**DRB Comments**

**PROJECT # 1004531**

**APPLICATION # 10-70317**

**RE: Tract 2A3A, McLeod Business Park**

BOUNDARY SURVEY
TRACTS 2-A-3-A, 2-A-3-D, 2-A-1 AND 2-A-2, McLEOD BUSINESS PARK

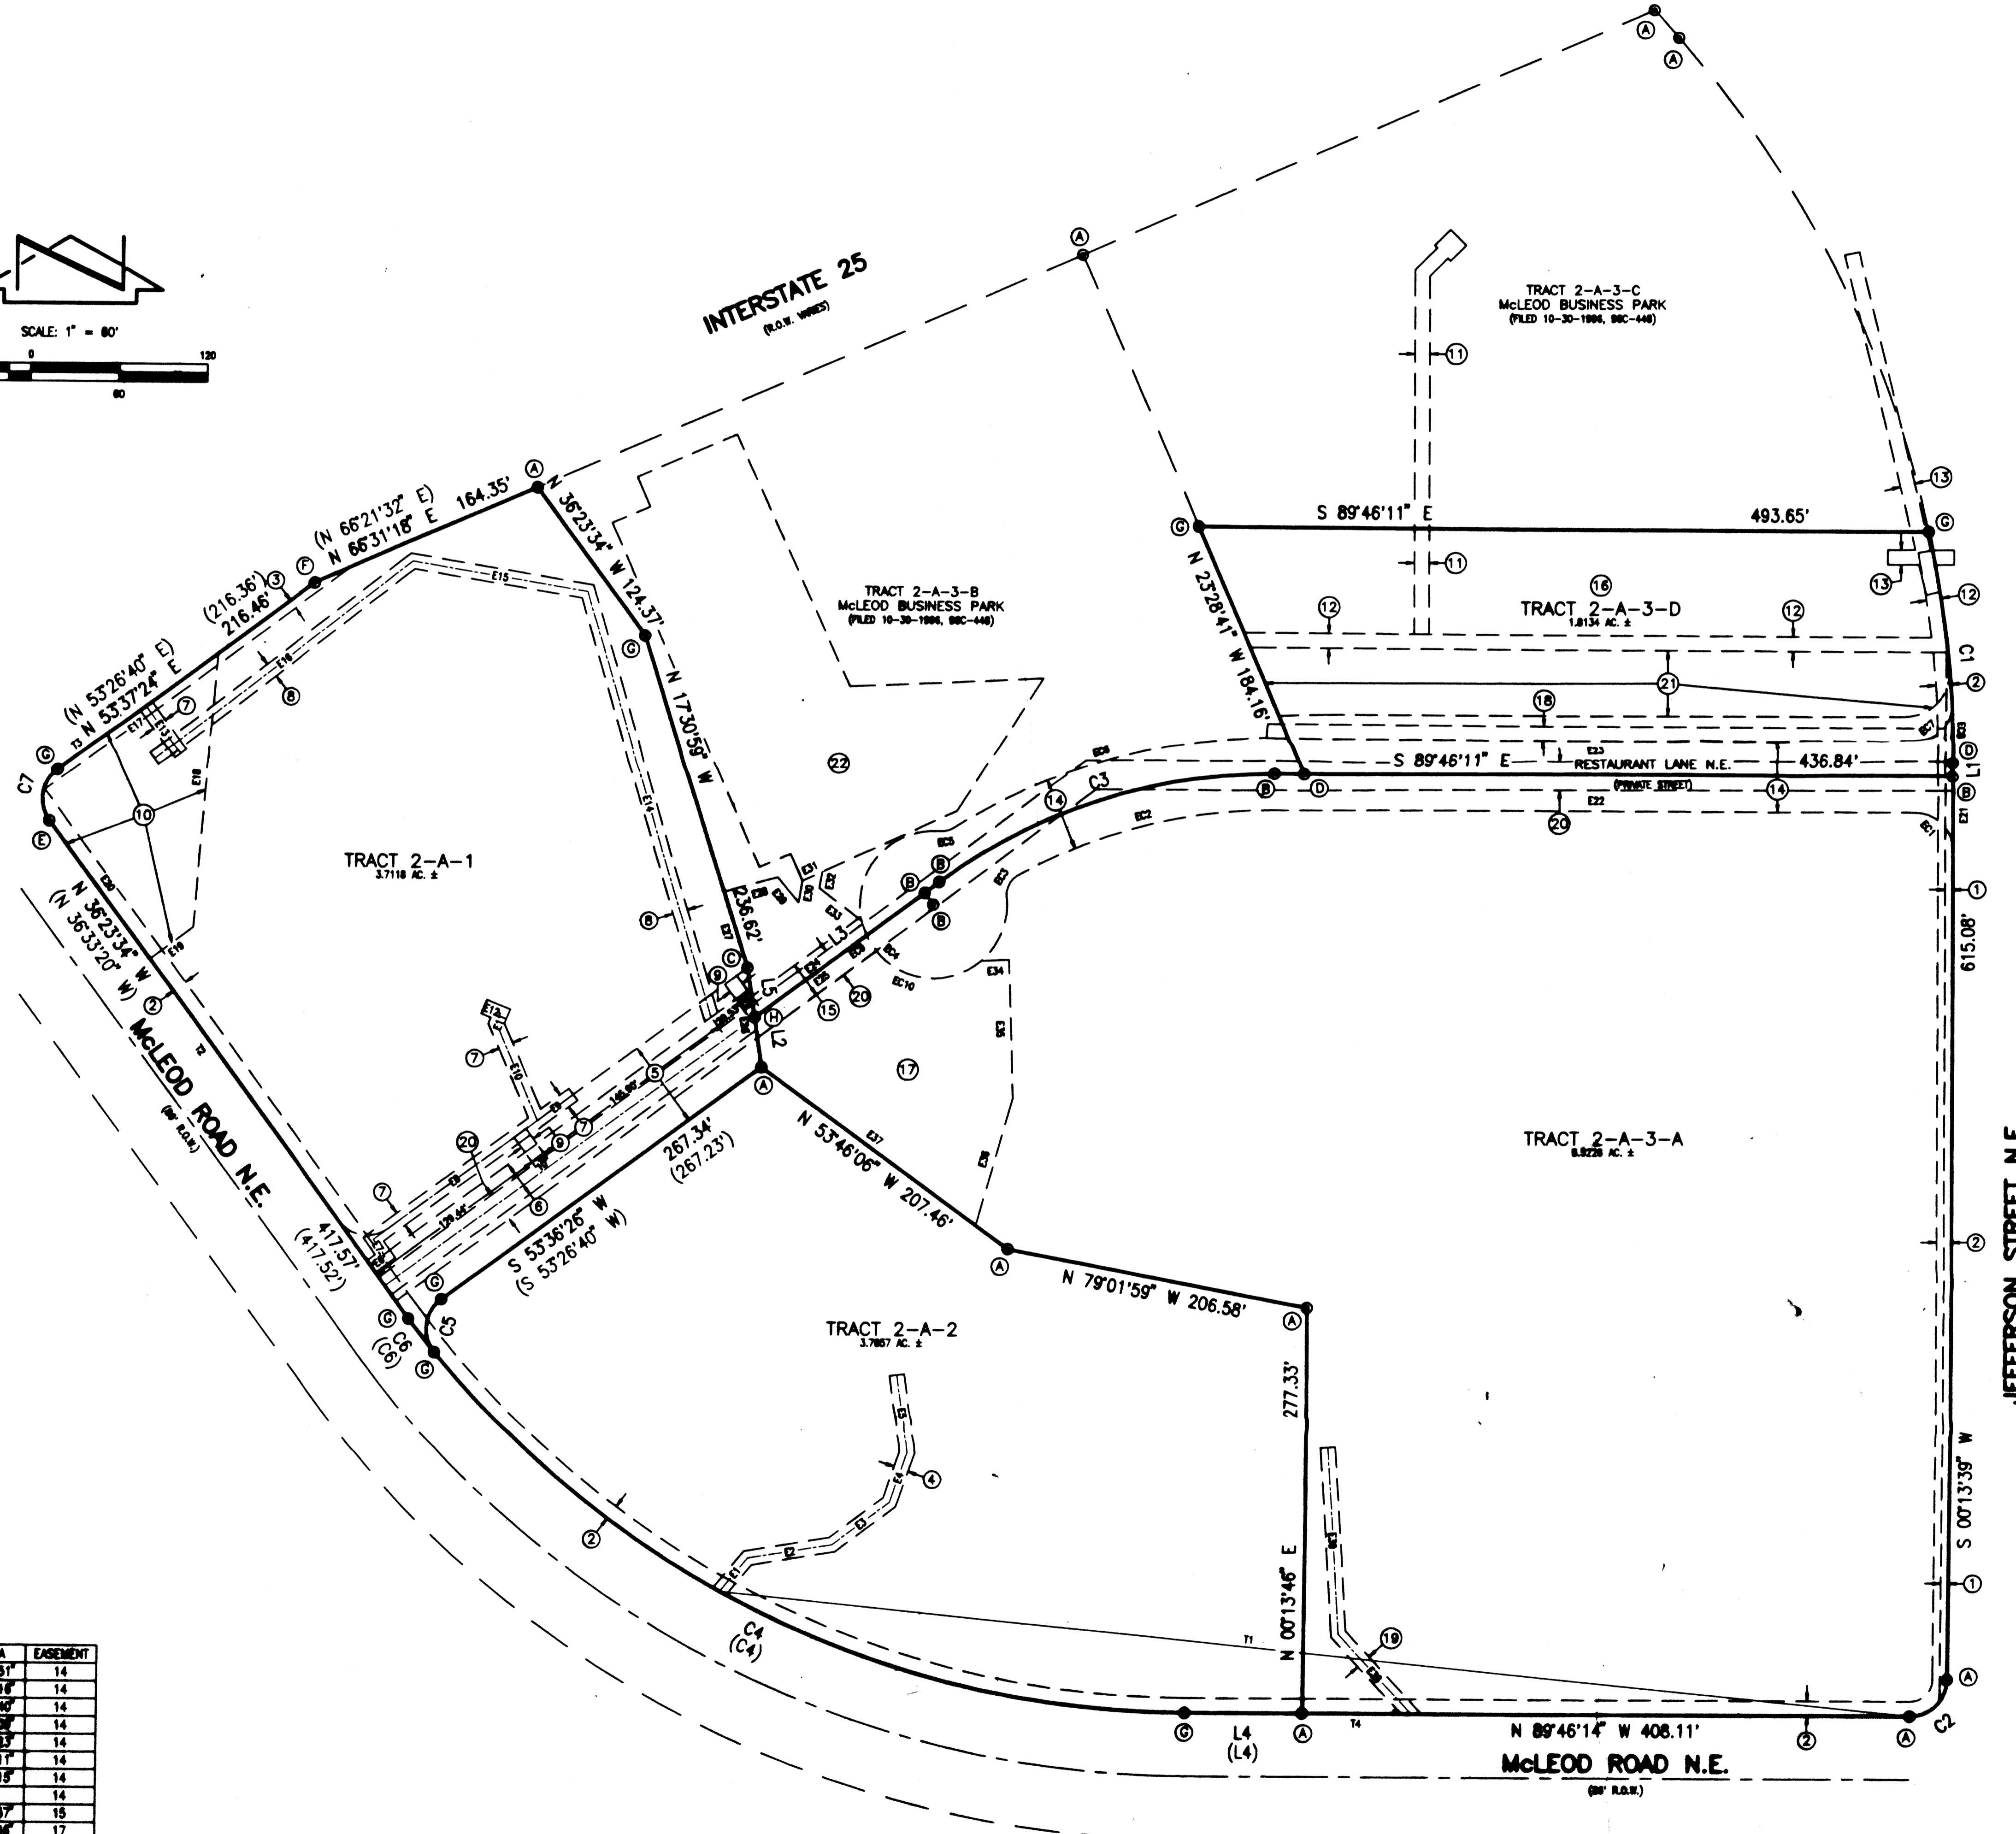
This is a "Shopping Center Site" per the Zoning Code, and a site plan approved by EPC is required (per § 14-14-2-2 of the Subdivision Ordinance, platting must conform to an approved site plan). There may be a previous site plan (Z-80-7?); if so this subdivision may conform, or if it does not conform perhaps it could be administratively amended.
